Planning Consultation Request

Application No.	2022/92406
Proposed Development:	Erection of 10 affordable dwellings, with access from Chapelgate and associated works, including resident play zone
Location:	Land Adj, 67, Chapelgate, Scholes, Holmfirth, HD9 1SX
OS Map Reference	SE 415859.4861 407150.9163
Applicant/Agent:	D5 Planning
Class:	Small Major Developments

**Consultation Response from KC,
Lead Local Flood Authority****2022/92406 Land Adj, 67, Chapelgate, Scholes, Holmfirth, HD9 1SX****Erection of 10 affordable dwellings, with access from Chapelgate and associated works,
including resident play zone****Date Responded: 25/08/2022****Responding Officer: Martin Stephenson****Responding Ref: 0****Documents reviewed by the LLFA:**

- Document Ref: 2205/CAL01 (A), Drainage Calculations, dated 08/04/2022
- Drawing Ref: 2205/100, Drainage Strategy, Rev P1 dated 07/04/2022 (appended to Drainage Calculations)
-

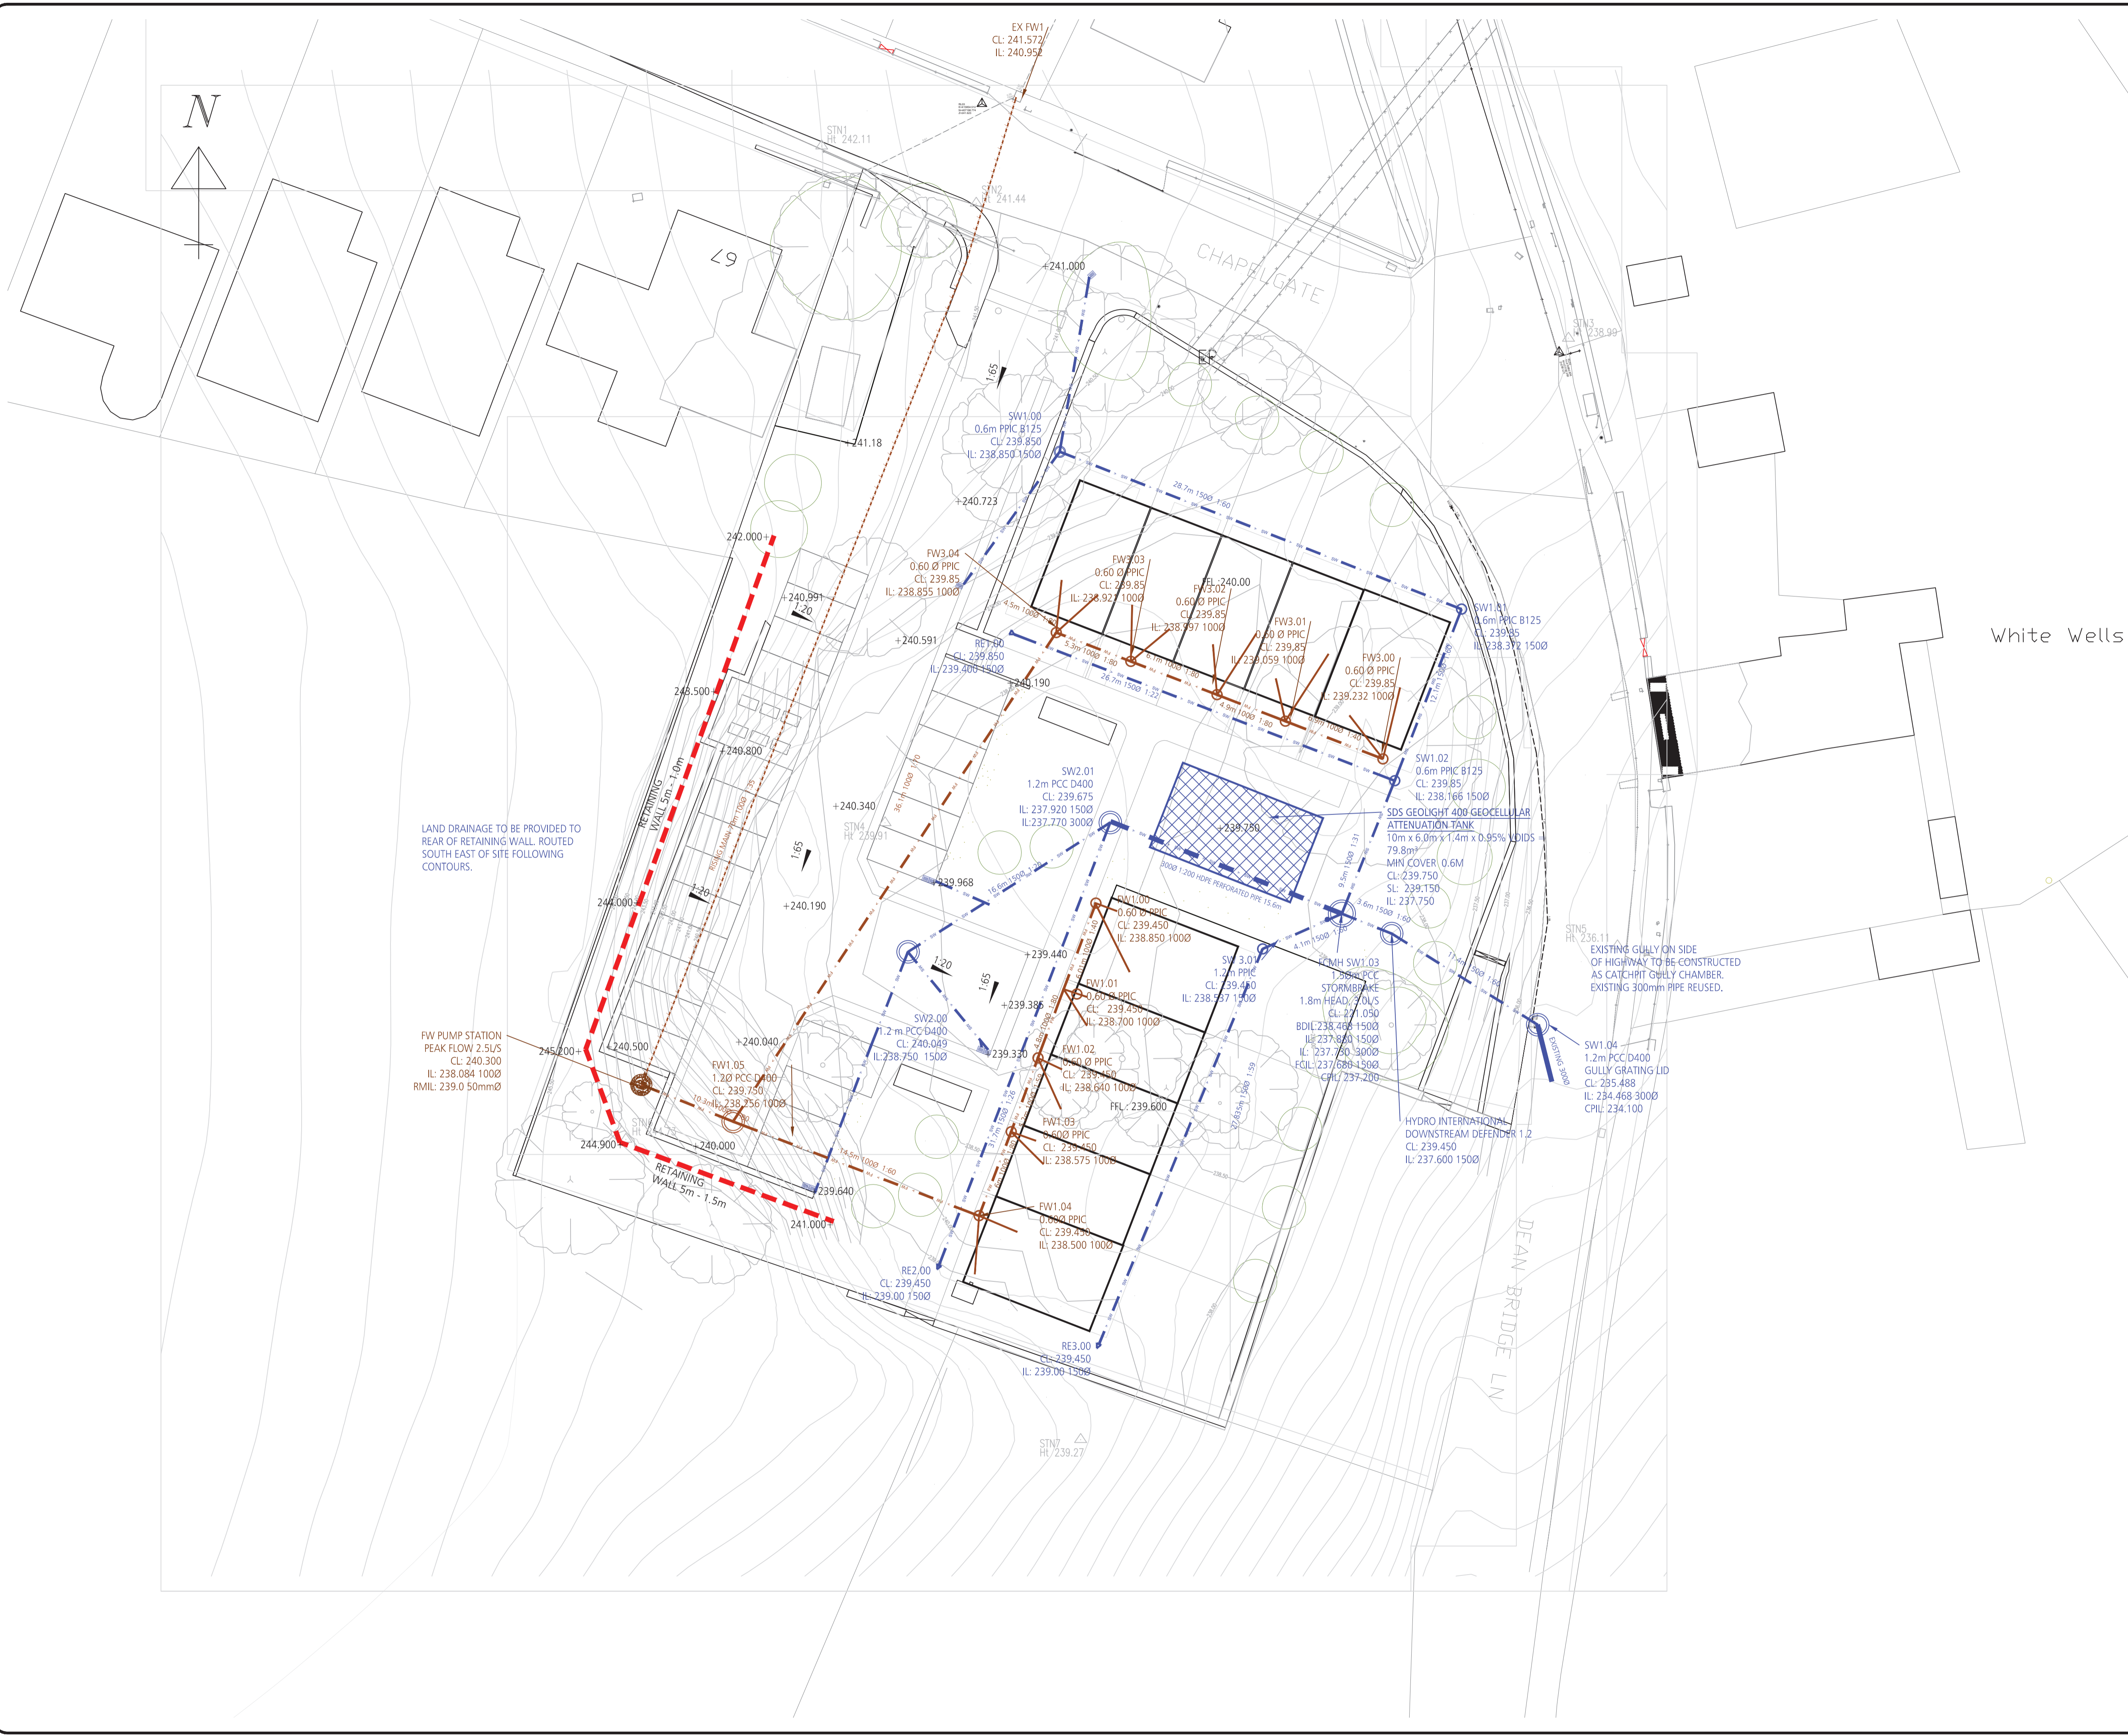
The above proposals **are acceptable** to the LLFA; however it is noted that the surface water discharge is proposed to connect to a 300mm dia highway drain. This drain is not shown on the Kirklees Council's mapping data and therefore further investigation will be required (such as a CCTV survey) to prove condition and eventual discharge point to a watercourse and that there is sufficient capacity in the drain to accept the proposed 3.0 l/s flow. Permission to connect to the highway drain may be required from Kirklees Council Highways Department.

Note further that the MH upstream of the proposed attenuation tank should be of the catch pit type to reduce the risk of siltation within the tank.
